## Northconnex EIS Submission – Construction - SSI 13\_6136

## Northconnex EIS - Submission - Construction

Figure 5-17 Motorway operations complex

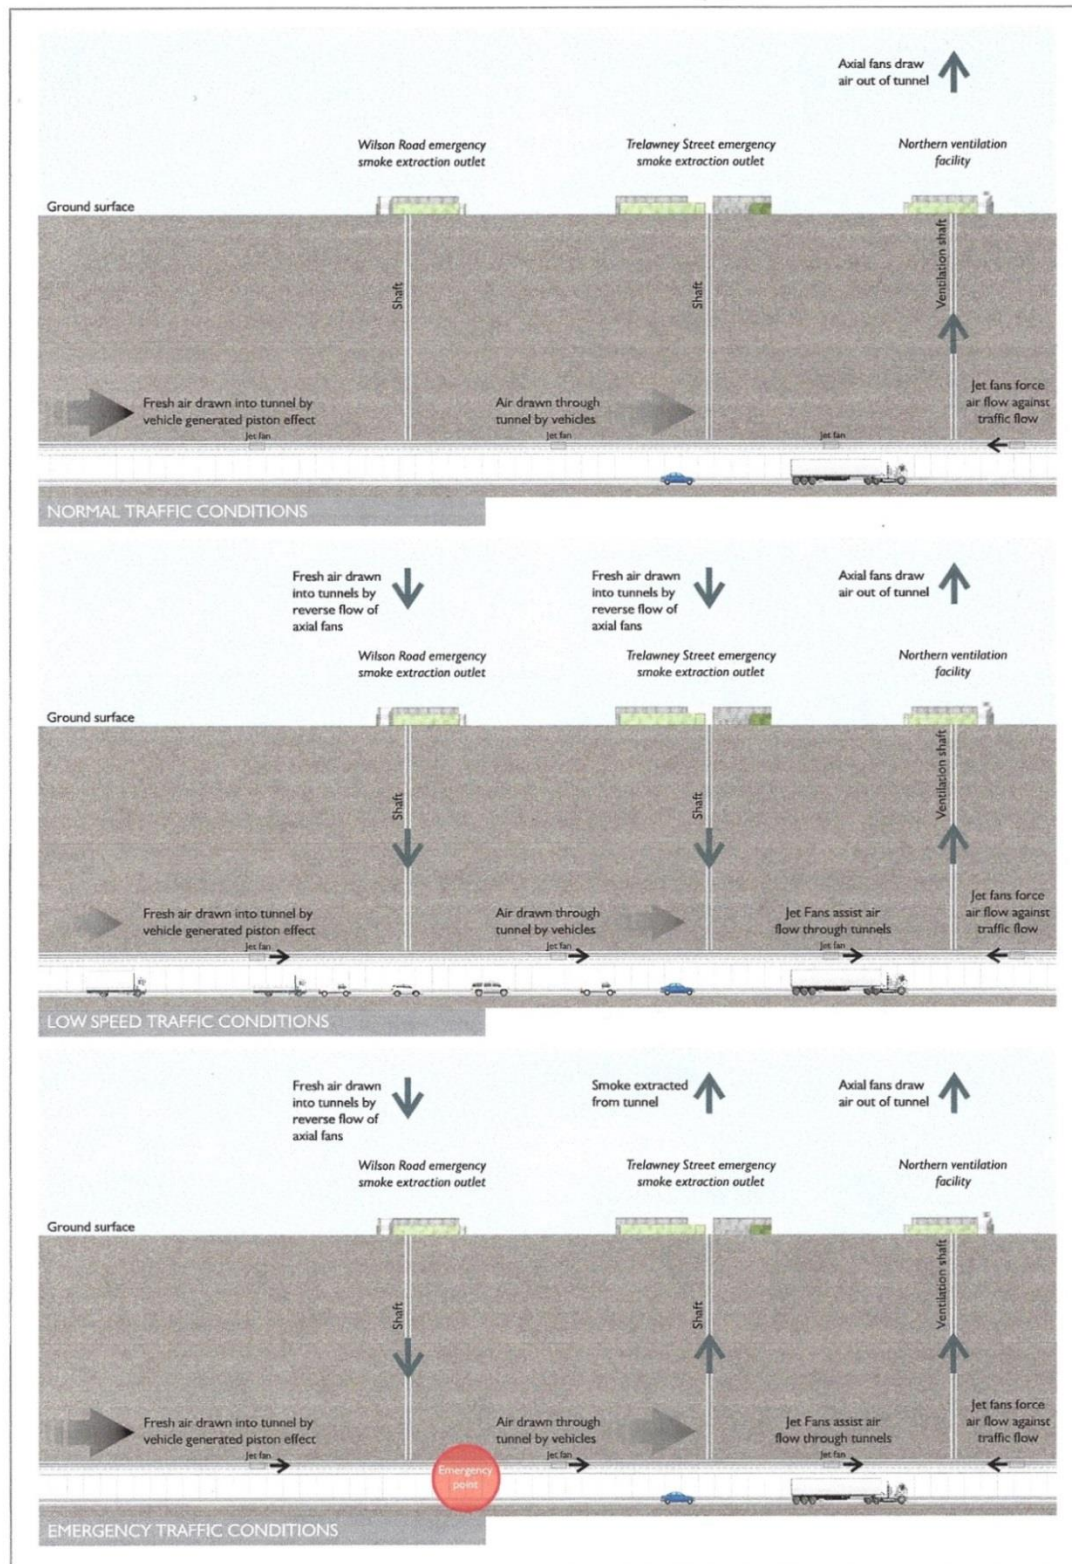
- if there is a facility to expel smoke, why not 'polluted' tunnel air in the event of a tunnel emergency or equipment failure
- **What measures will be in place to avoid such a possibility?**

- the excavation shaft will do only be deep but also wide considering the activity
- **What are the exact dimensions? Will it be largely filled on completion of the tunnelling? What in-shaft facility will there be in the operational phase? Has the remaining security/safety risk associated with the operational shaft been assessed?**
